State of Washington
DEPARTMENT OF FISH AND WILDLIFE

April 28, 2016

SUBJECT: Palomino Fields Development Agreement (P-07-31) surrounding Currier Creek – Proposal to Construct in Five Phases

Phasing Plan

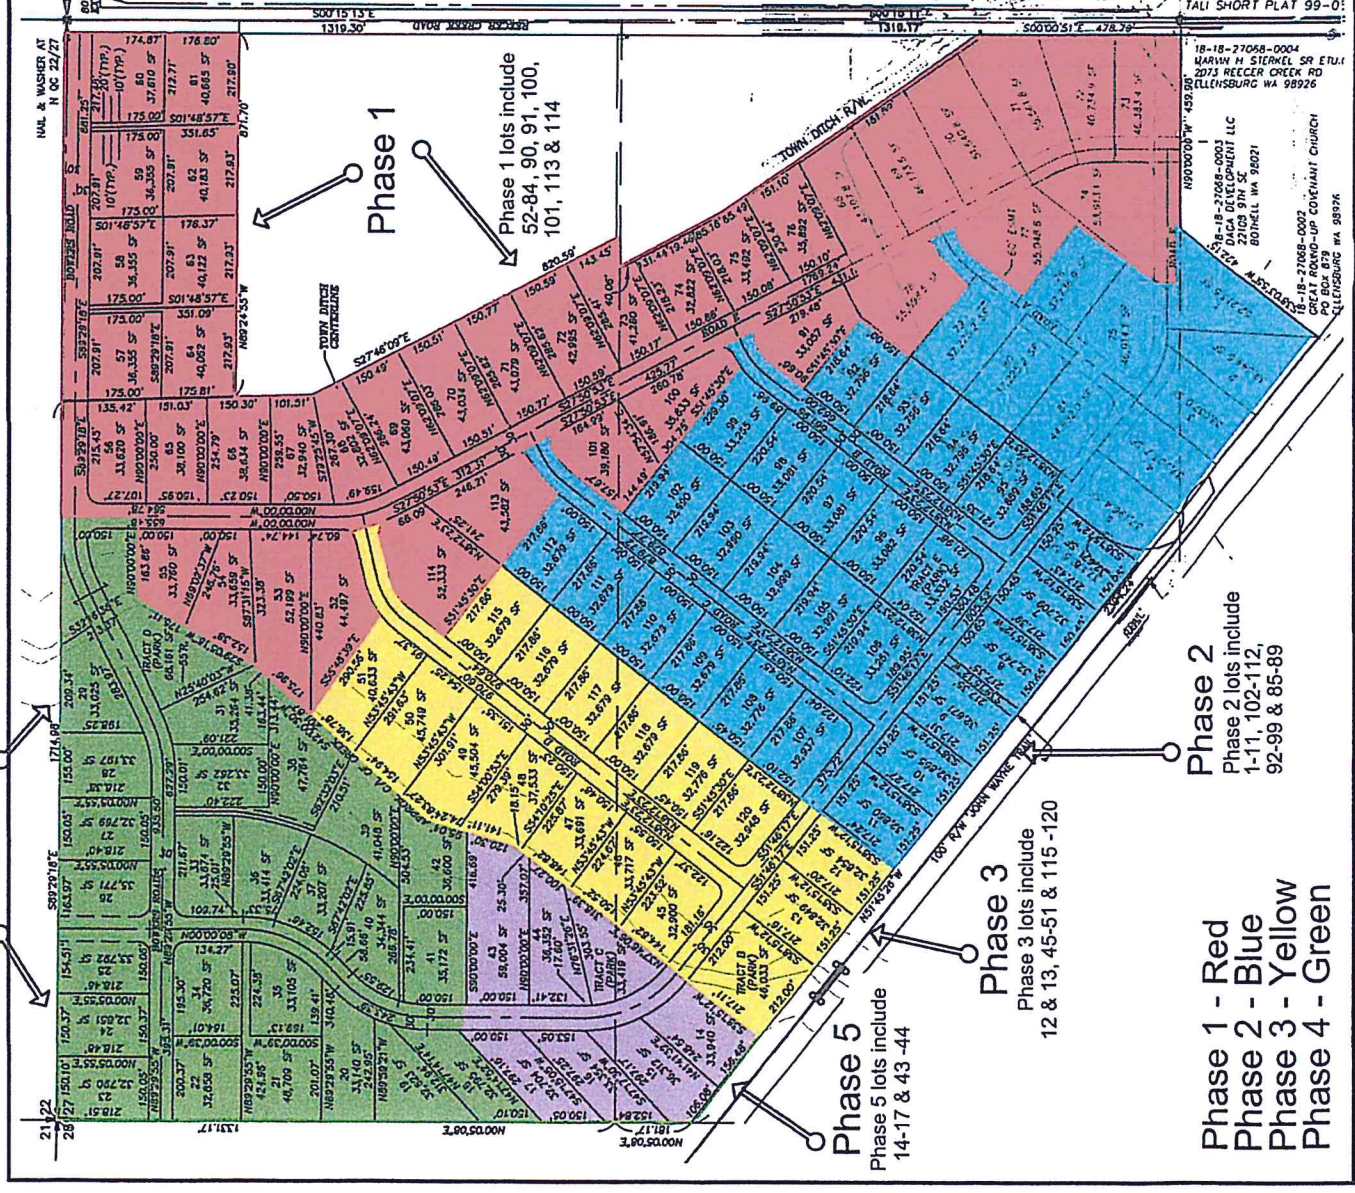
We do not have detailed phasing plans for this project, but our interest is in ensuring the fish and wildlife habitat associated with Currier Creek is incorporated into the planning/phasing and that the creek, its buffer, and the floodplain are protected to the greatest extent possible. As such, we have the following recommendations for inclusion in Phase 1 to protect fish and wildlife habitat:

- All utilities, including septic plans, should be properly laid out and planned in Phase 1.
- The four wetlands referred to in the 2008 Hearing Examiner's findings should be clearly identified on the plans along with their buffers to ensure their protection.

- The 100 foot buffer from the top of bank on each side of Currier Creek should be clearly identified on all plans and in the field to ensure its protection and to prevent encroachment into the buffer.

- All drainage features for stormwater and flood water should be planned and installed as part of Phase 1. The aerial photos in the attachment demonstrate that much of this development is within an active floodplain.

- All stream crossings (roads and trails) will require HPAs from WDFW and should be planned early in Phase 1 to ensure ease of constructability as well as provide the ability to construct adequately sized structures without impacting existing structures/infrastructure.

- We note that most of the parks are located within the 100 foot buffer for Currier Creek. Please provide plans for these parks, demonstrating that the functions of the buffer will not be impacted by development or actions in the parks.
